**Consultation Response from KC,  
Lead Local Flood Authority**

**2023/91491 Prickleden Mills, Woodhead Road, Holmfirth, HD9 2JU**

**Date Responded: 30<sup>th</sup> November 2025**

**Further to our previous comments of 20<sup>th</sup> December 2023, 23<sup>rd</sup> July 2024, Kirklees Flood Management & Drainage acting as LLFA OBJECTS to this application.**

Figure 5.3 Floodplain Compensation Usage

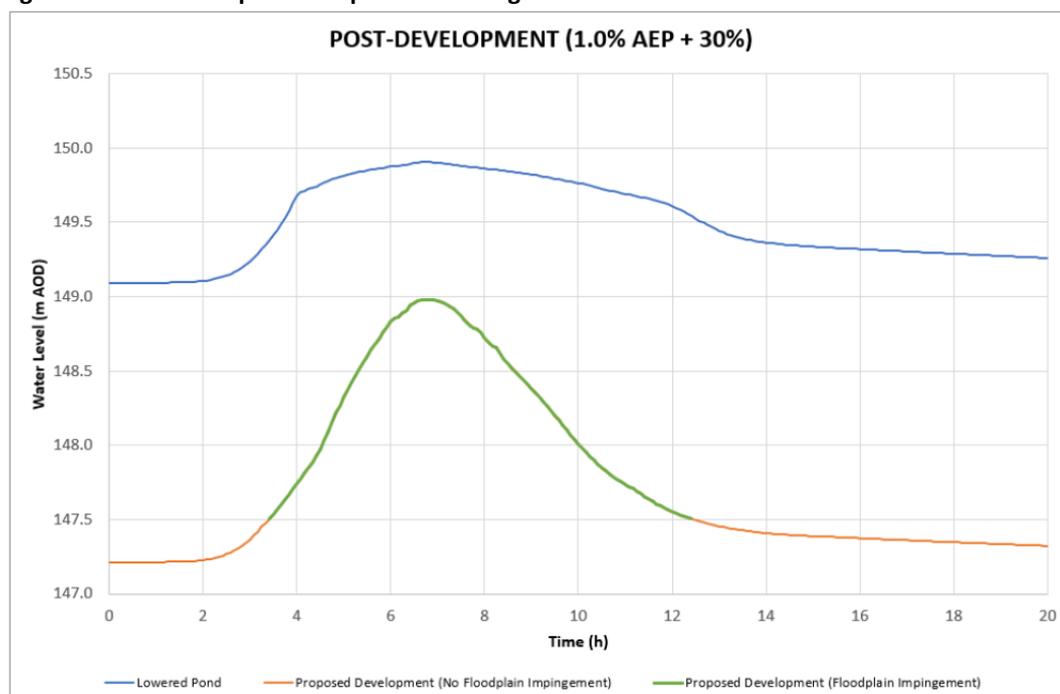
The design of the pond including overflows and how it best protects this site is crucial. Previous submissions for this site have gone into much more detail on design. We would expect the pond to be drained, and a design agreed with emergency drain down, and acceptable risk to the new buildings before any other work on site commences.

Figure 5.1 Flood Zones 2 and 3 Outlines

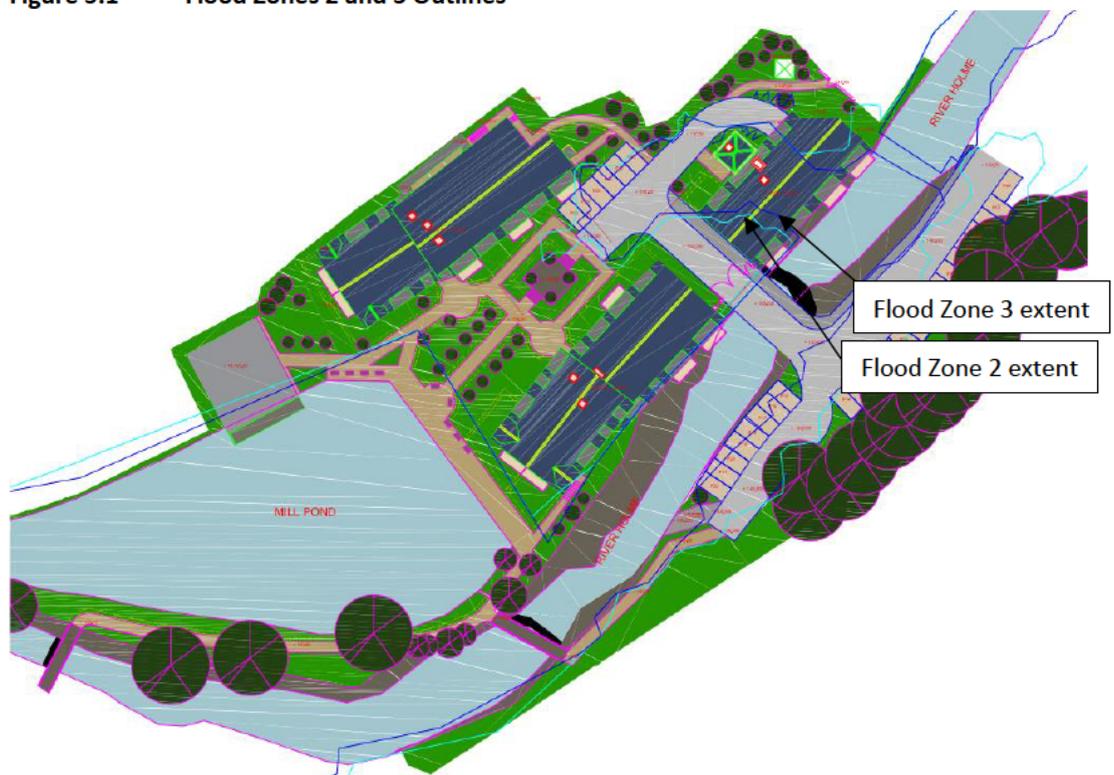
**A sequential test must be carried out.** As apartment blocks, access roads are located in flood zone 3a (SFRA 2016). Please note that under provisional plans for a revised SFRA, this area becomes flood zone 3b which is incompatible with housing which is listed as a 'more vulnerable' use.

The opportunity to perform an on-site sequential approach to negate the need for a sequential test has not been taken. For this to occur, all development would be required to be located in the areas of the site shown as flood zone 1.

Figure 5.4 Location of undercroft car park

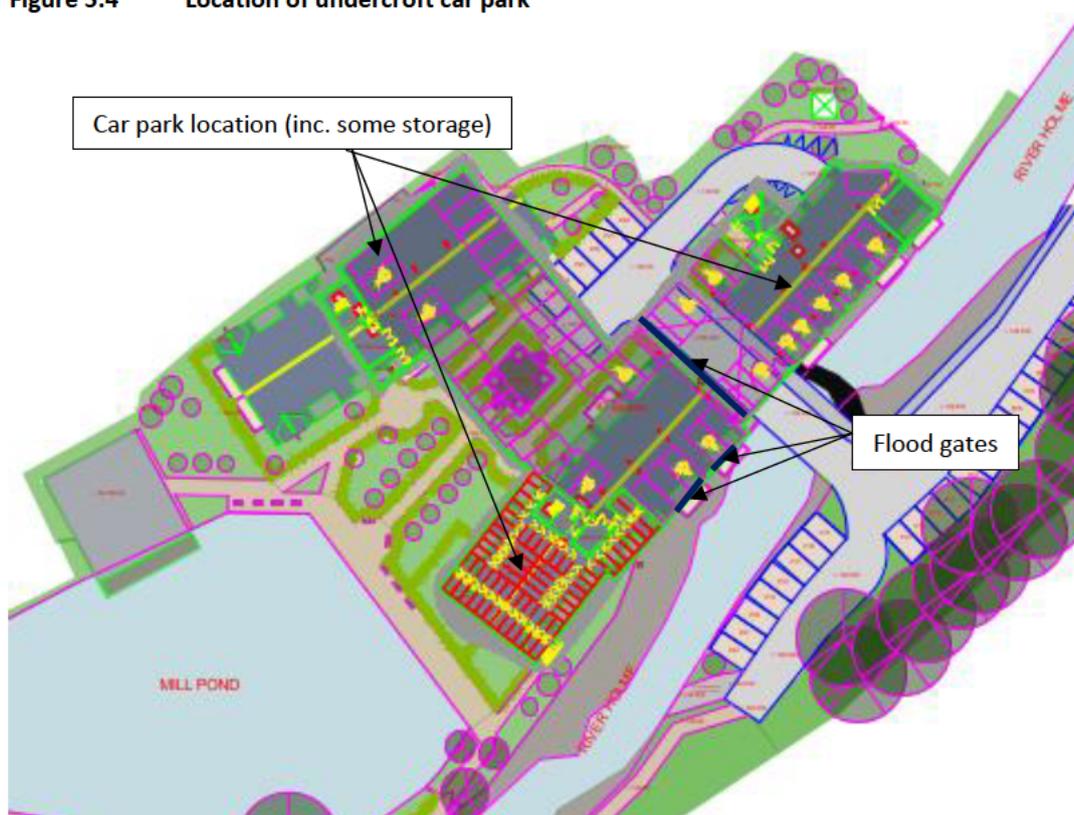
The undercroft car parking is a concern **due to the potential rapid inundation and loss of life.** Any defences such as walls should be assumed to fail. We therefore would only accept undercroft parking if entrances to it were above the 0.1% annual probability flood level, i.e. flood zone one. It would be prudent to look at climate change/freeboard to allow for modelling error.
